Recommendation Report for Planning Permission for Works or Extension to a Dwelling

REF NO: BR/28/21/HH

LOCATION: 20 Southdown Road
Bognor Regis
PO21 2JR

PROPOSAL: Single storey rear extension.

PART GROUND FLOOR PLAN  
SHOWING PROPOSED EXTENSION

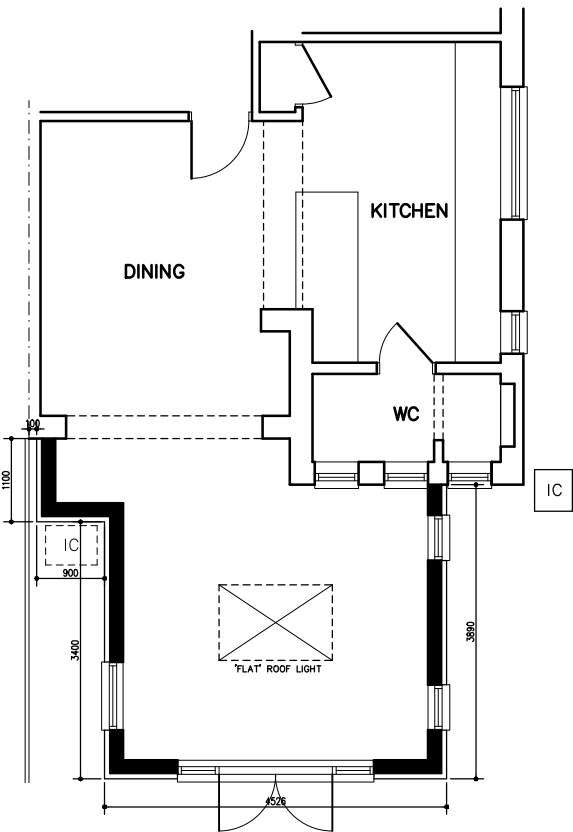
A rear extension measuring approximately 5.6m wide by 4m in length is proposed, there is a small dogleg to accommodate a drain cover taking the bulk of the building away from a shared Northern boundary.

The development does not encroach on the existing separation gap between the application site and the dwelling to the South providing a 2.3m gap from the edge of the extension to the boundary. A dog leg created to accommodate an external drain cover brings the bulk of the extension into the centre of the site, greatly relieving overbearing concerns on the boundary shared with the adjoining neighbour to the North. It is believed that the extension accords with the 45-degree rule on either side in agreement with the Arun design Guide.

FOR		
MR & MRS G. COTTON		
SITE		
20 SOUTHDOWN ROAD, BOGNOR REGIS, WEST SUSSEX, PO21 2JR		
TITLE		
PROPOSED EXTENSION		
EXISTING & PROPOSED ELEVATIONS		
SCALE	DRAWN	DRAWING NO.
1:100	AH	02
@ A3	01/20	REV C

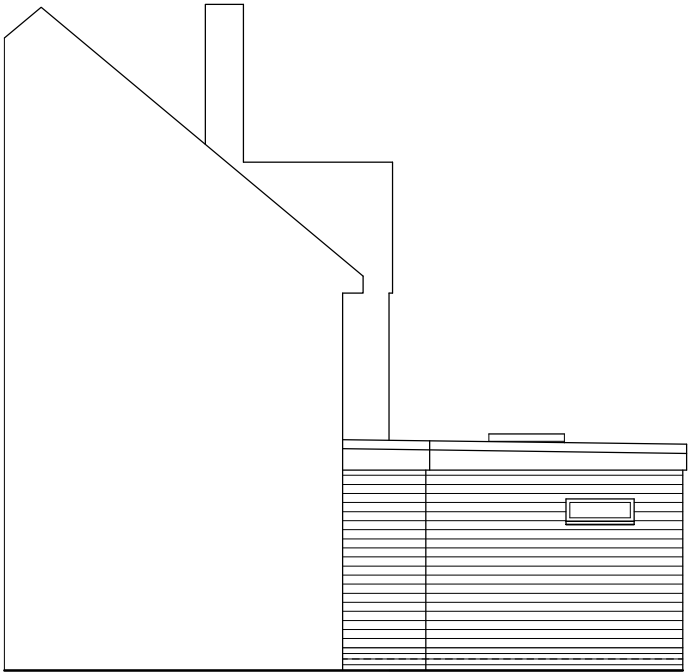
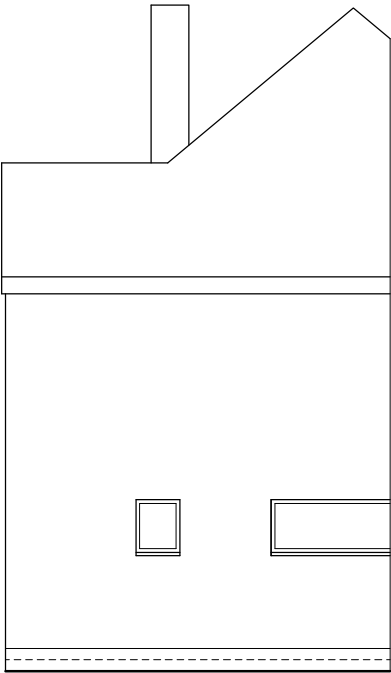
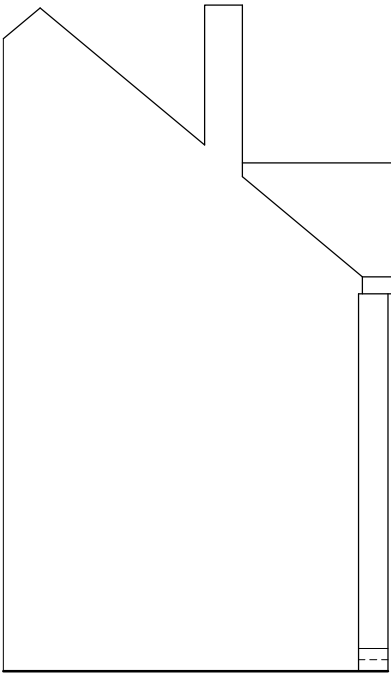
It is proposed that the materials will be a departure to those currently in use on the host dwelling, however differing styles are considered appropriate when dealing with rear extensions, it also adds to the modern styling of the proposal. The eaves will be considerably lower than the existing 2 storey house, it is seen to be well integrated with the host dwelling.

New fenestration has been proposed to the Northern, Eastern and Southern elevations. To the North a high-level window is proposed, there are no concerns raised from overlooking from this. To the South two long windows have been proposed; it is noted that there are existing windows to the Southern elevation and the proposed are considered acceptable due to their increased separation distance of 1m,

when compare with the existing. All other fenestration is to face the private rear amenity space. It is therefore considered by virtue of being overbearing, overshadowing and overlooking that the proposed extensions accords with policy D DM4 of the Arun Local Plan.
